From: Juan Baeza
Sent: 17 June 2019 14:18
To: [REDACTED]
Cc: Kate Giddings
Subject: FW: WA/23/19/DOC

RA / 674 / 100 D

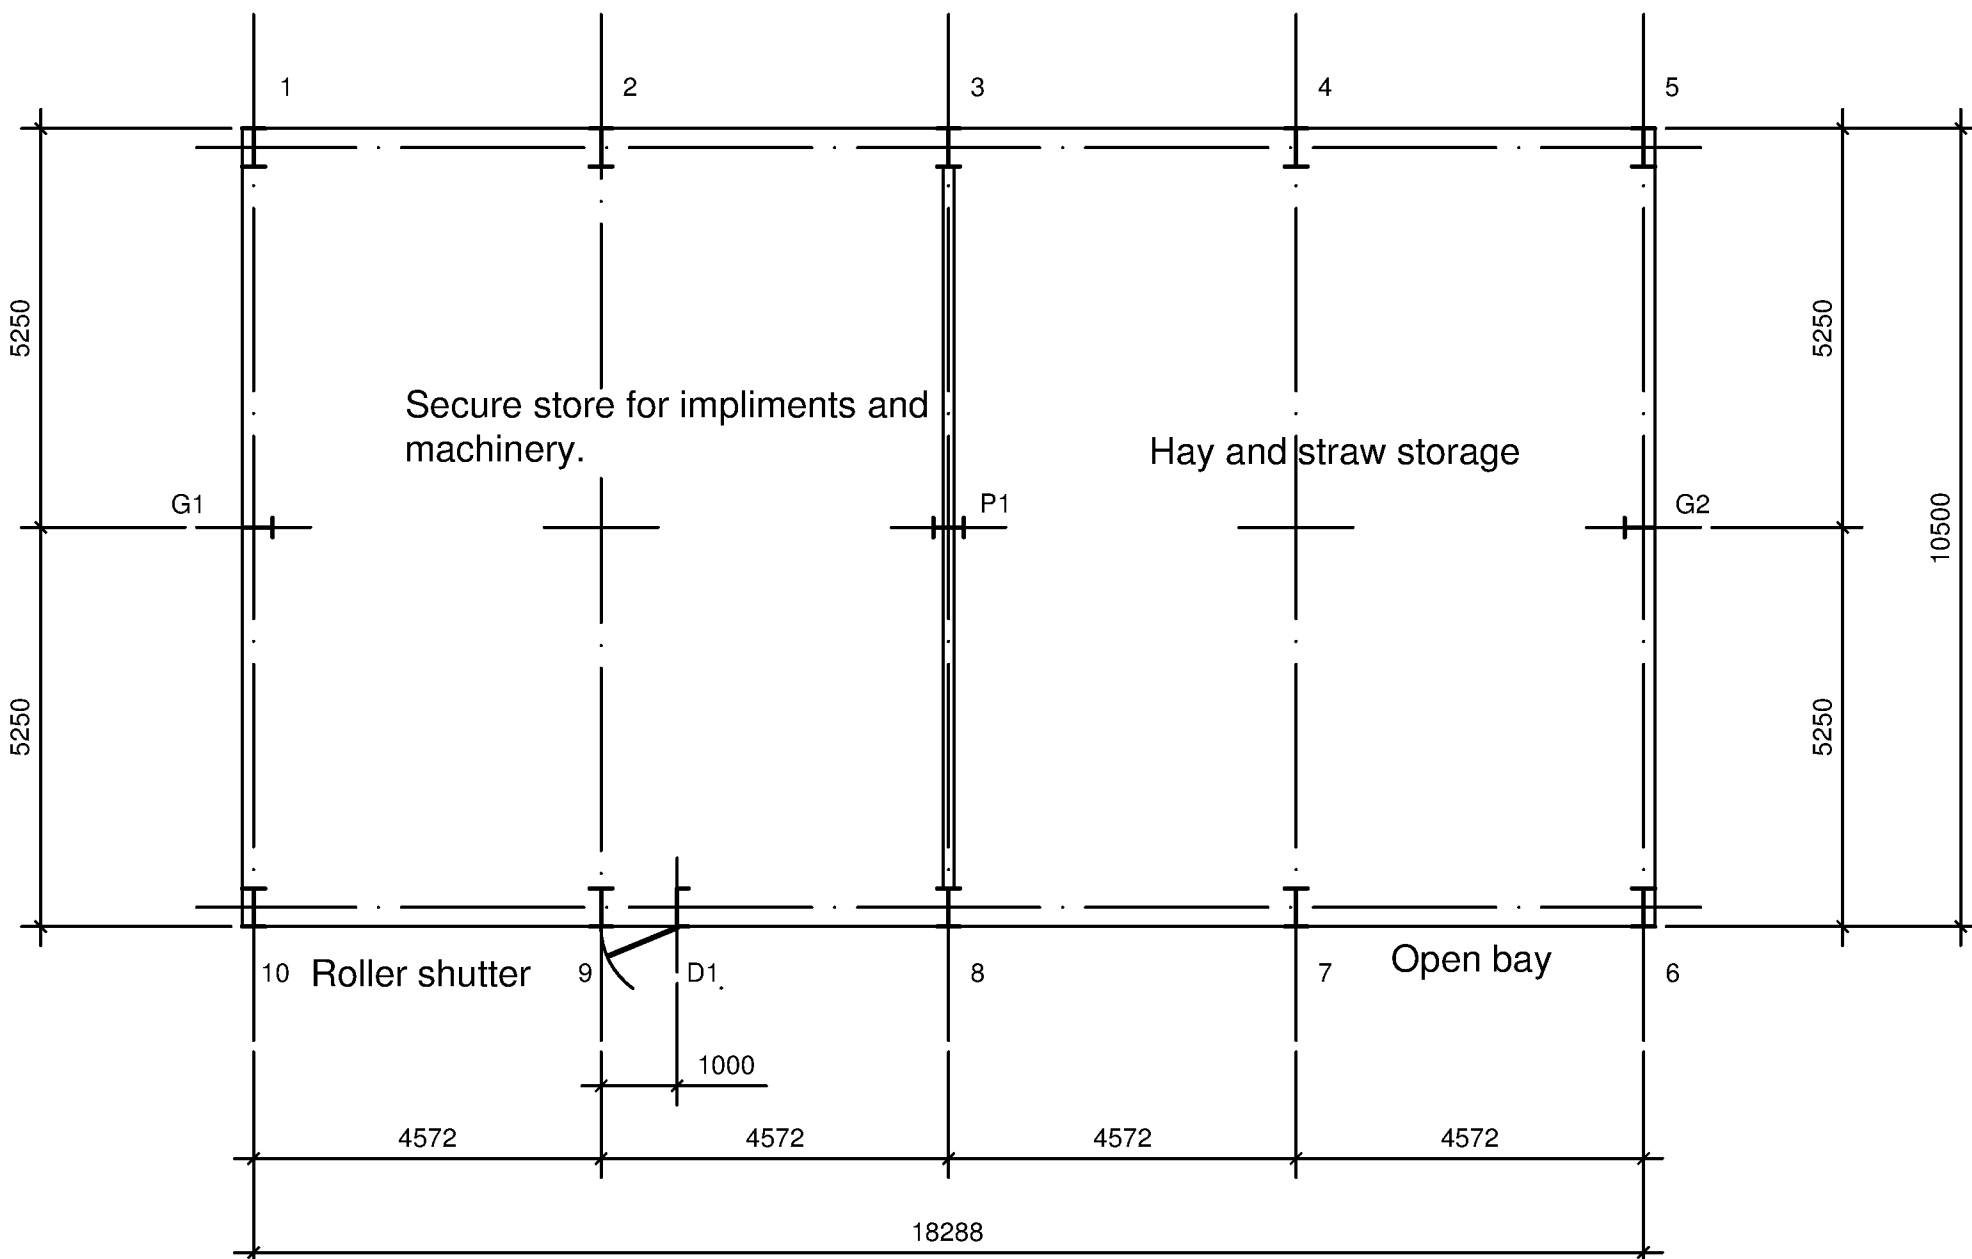
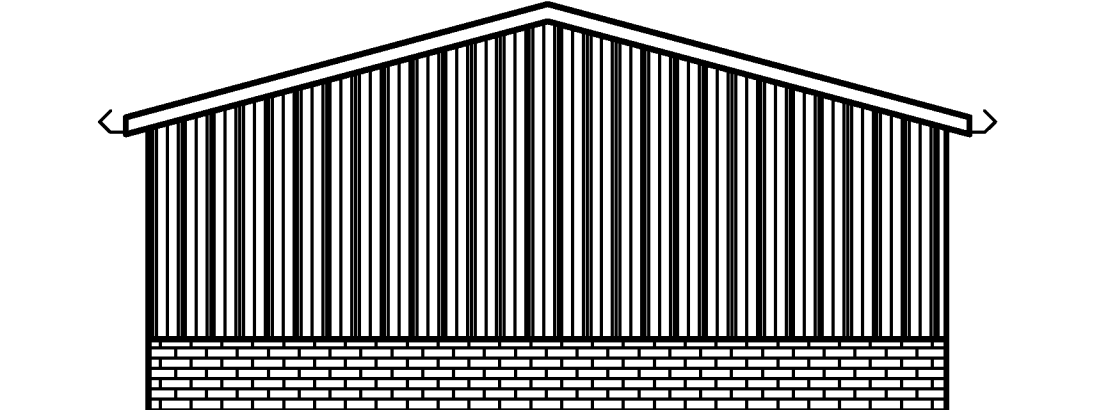
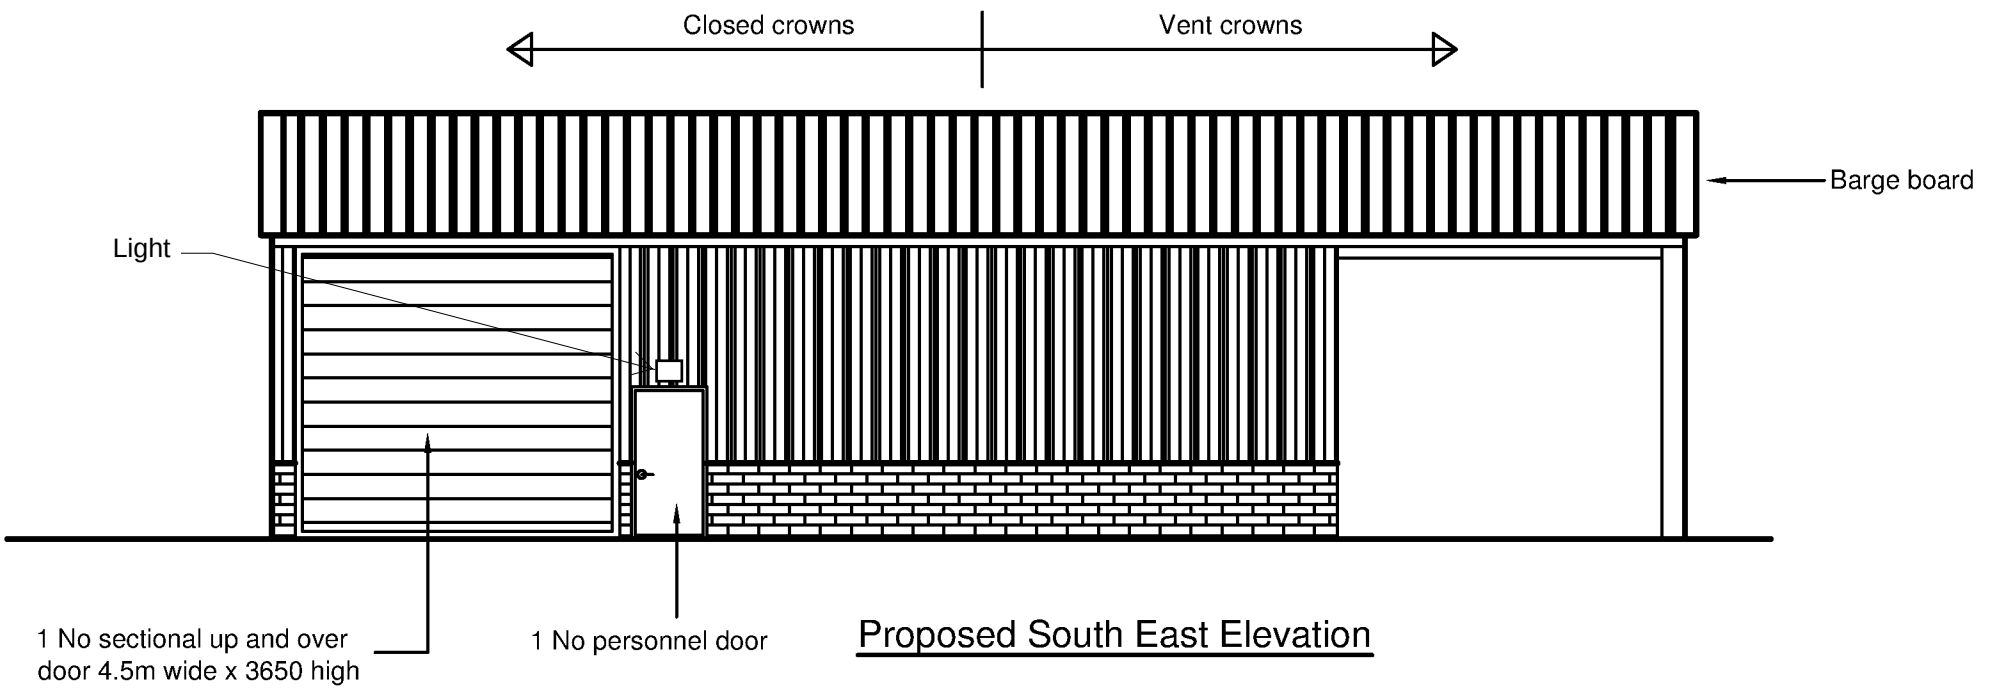
- type of appliance
- height of fixture
- position of fixture
- illumination levels
- light spillage

Further to your email 31st May 2019 and our telephone conversation today regarding the objection of environmental health to the lighting details I confirm that the details of the light are on the data sheet provided in the application and the position and location of the light is marked on the plan.
